**KIRKLEES METROPOLITAN COUNCIL
INVESTMENT & REGENERATION SERVICE**

Reference No:	2025/62/93078/E
Site Address:	14, Millwater Avenue, Thornhill Lees, Dewsbury, WF12 9QN
Description:	Erection of two storey side and rear extension
Recommending Officer:	Jennifer Booth

DECISION - REFUSED

OFFICER REPORT

PROPOSED GROUND FLOOR LAYOUT

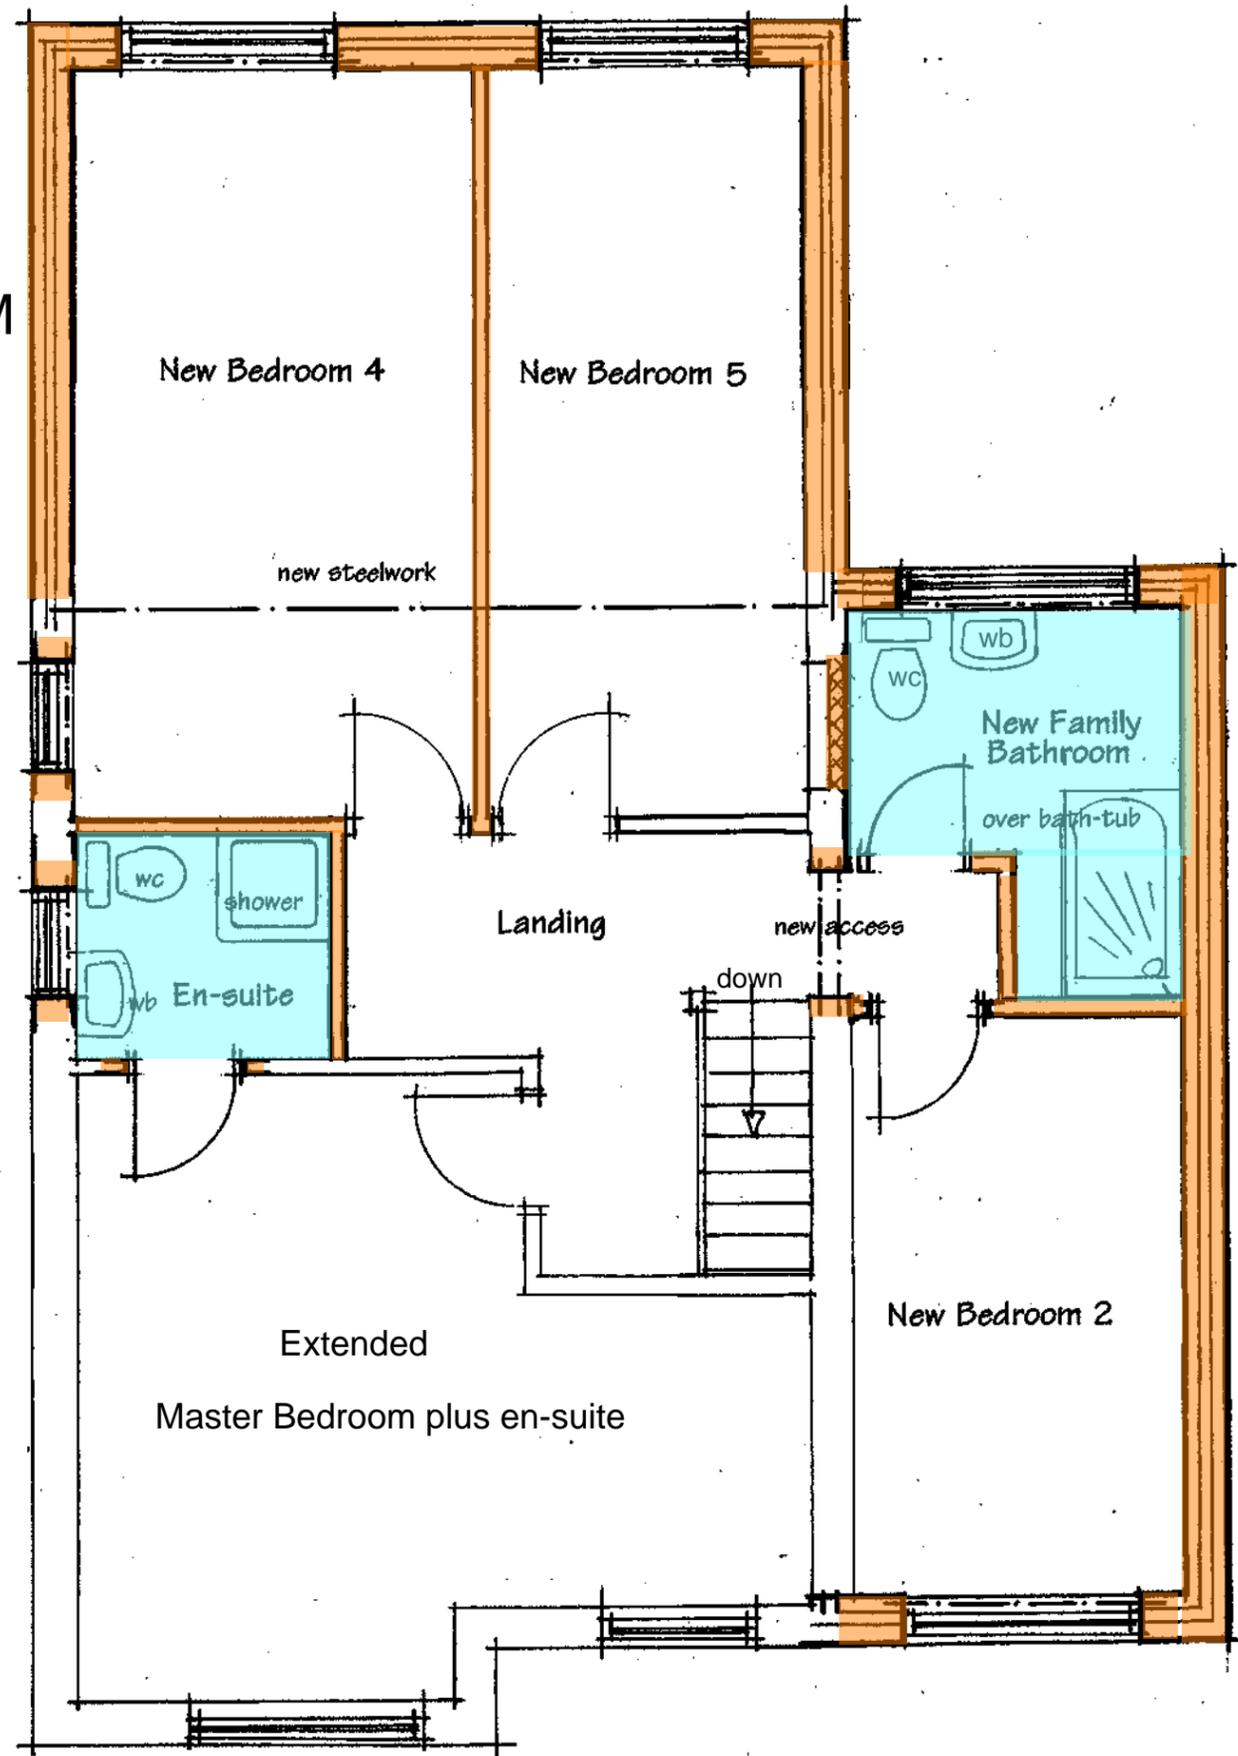
Although the trees that previously occupied the rear of the site appear to have been removed without consent, they were protected by a Tree Preservation Order. As such, the proposal must be assessed on the basis that the protected trees remain in situ. When considered in this context, the

extensions would fall within the former crown spread and root protection area, and the development would therefore pose a significant risk to the health and retention of the protected trees. Their loss would be detrimental to the established verdant character of the area and weighs substantially against the proposal in visual amenity terms.

The applicant has failed to demonstrate that the proposed rear extension could be constructed without harming the root protection areas of the adjacent protected trees. Given the proximity of the site for the rear extension to protected trees, within and adjacent to the grounds of 14 Millwater Avenue, the proposed extension would likely to be built over the root protection area and would be within the crown spread. The proposals would, therefore, be highly likely to lead to damage to the protected trees which would negatively impact the green and leafy character of Millwater Avenue. Their potential loss, therefore, would not be considered to be acceptable in terms of policies LP24 & LP33 Kirklees Local Plan and Chapters 12 & 15 of the National Planning Policy Framework.

PROPOSED REAR ELEVATION
PROPOSED FRONT ELEVATION

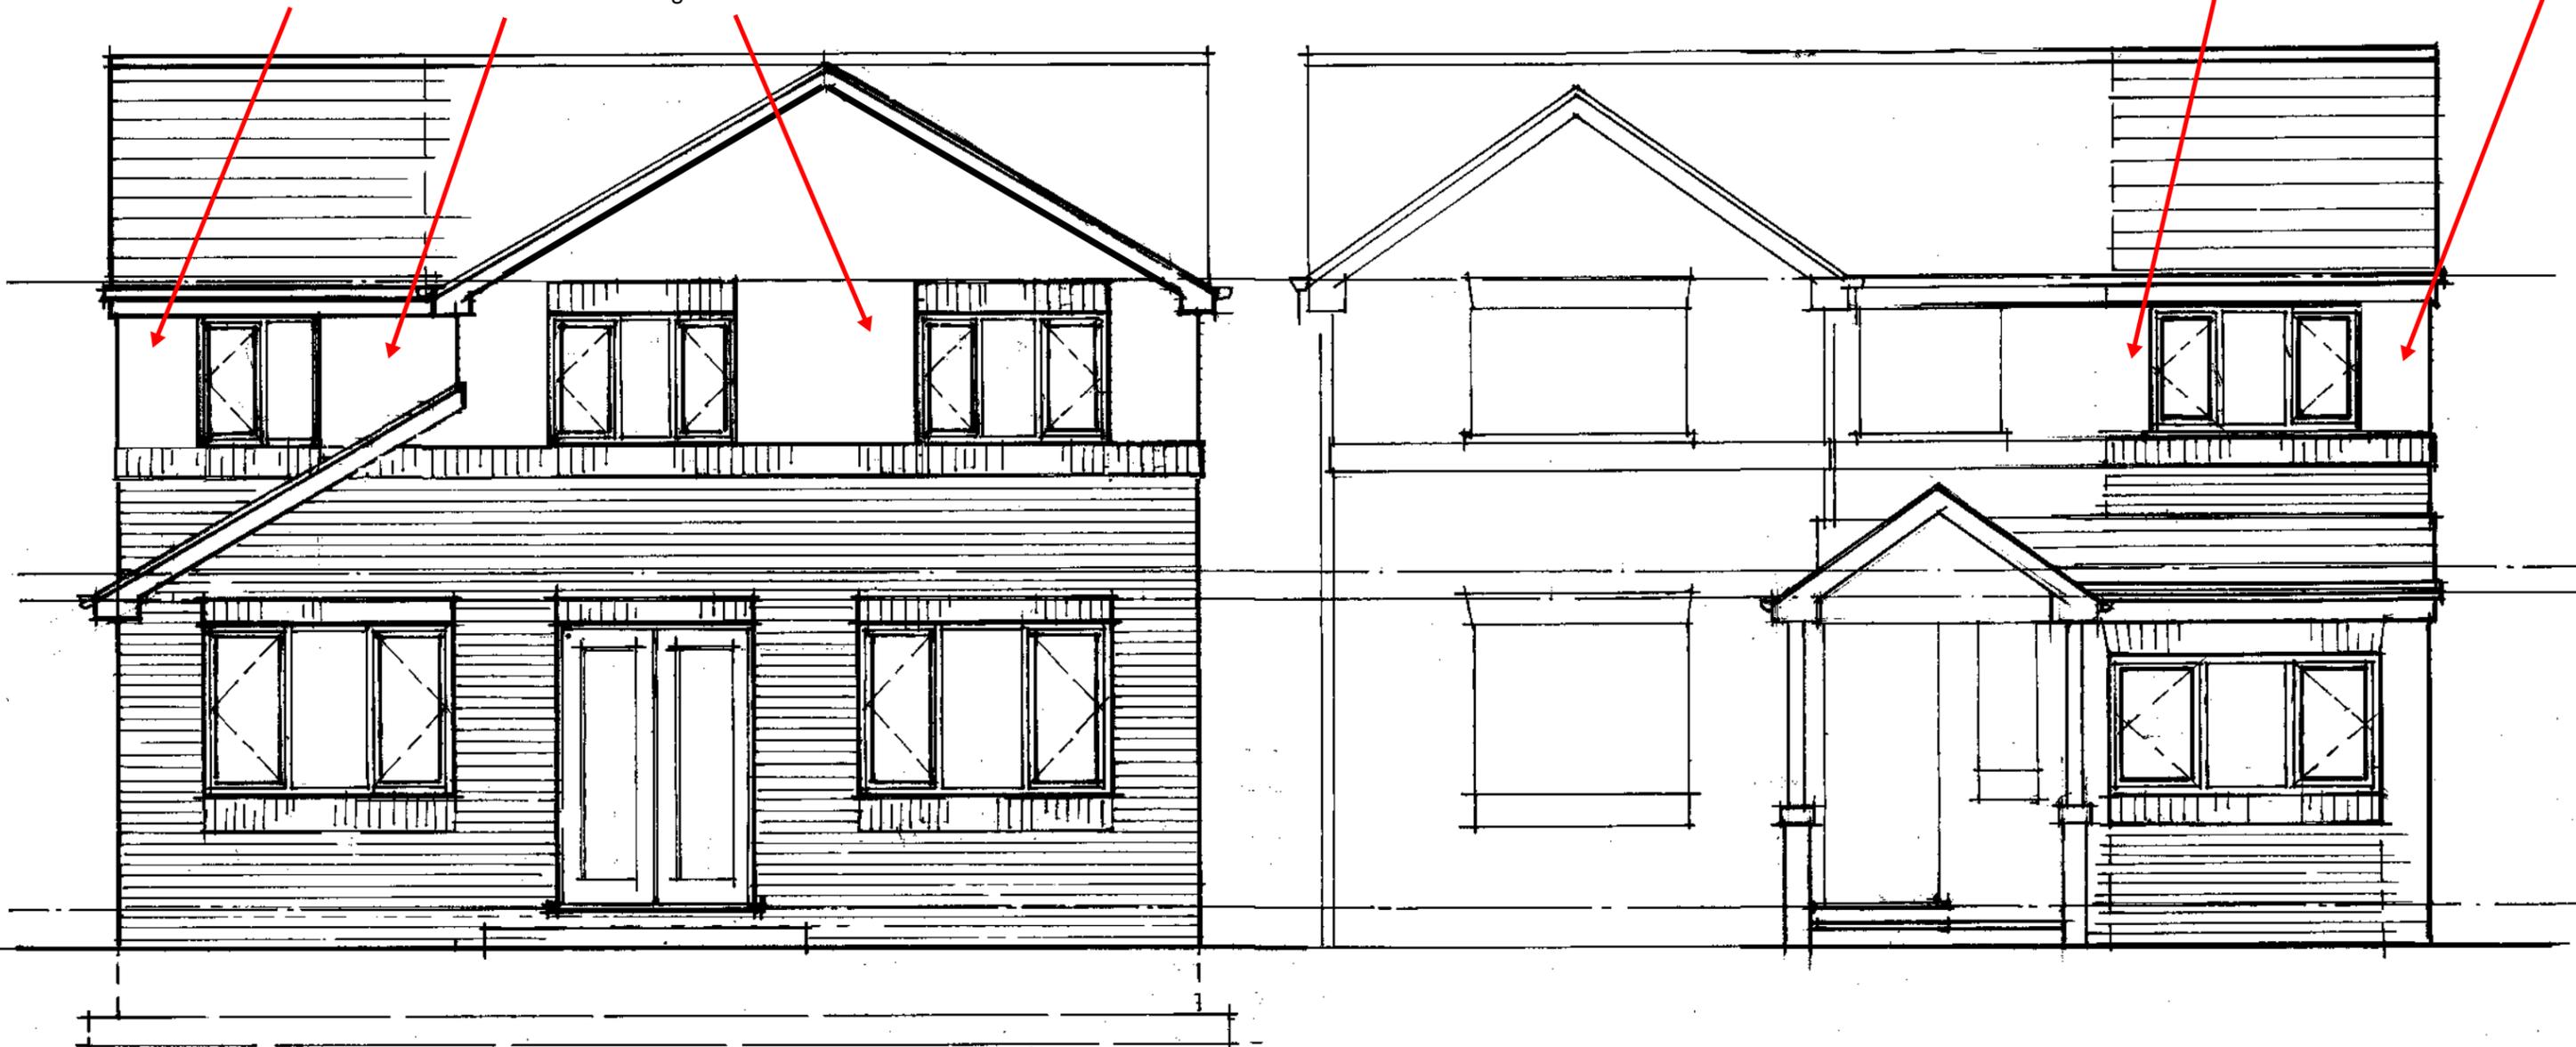
The proposed single- and two-storey rear extensions are considered to be of an acceptable scale in principle, given the detached nature of the property and the generous size of the curtilage. The use of matching materials and appropriate fenestration would ensure the additions form a coherent and sympathetic relationship with the host dwelling. However, the works fall within the crown spread of protected trees, and the development has the potential to result in the loss of a tree subject to a Tree Preservation Order. Such a loss would cause harm to the established leafy character of the area and therefore weighs against the proposal in visual amenity terms.

Having taken the above into account, the proposals would broadly be acceptable in terms of scale and appearance. However, the siting, close to protected trees could result in their loss which would be harmful to the leafy and green character of the area. Therefore the proposals fail to comply with Policy LP24 and LP33 of the Kirklees Local Plan, KDP 1 & 2 of the House Extensions & Alterations SPD and the aims of chapter 12 of the National Planning Policy Framework.
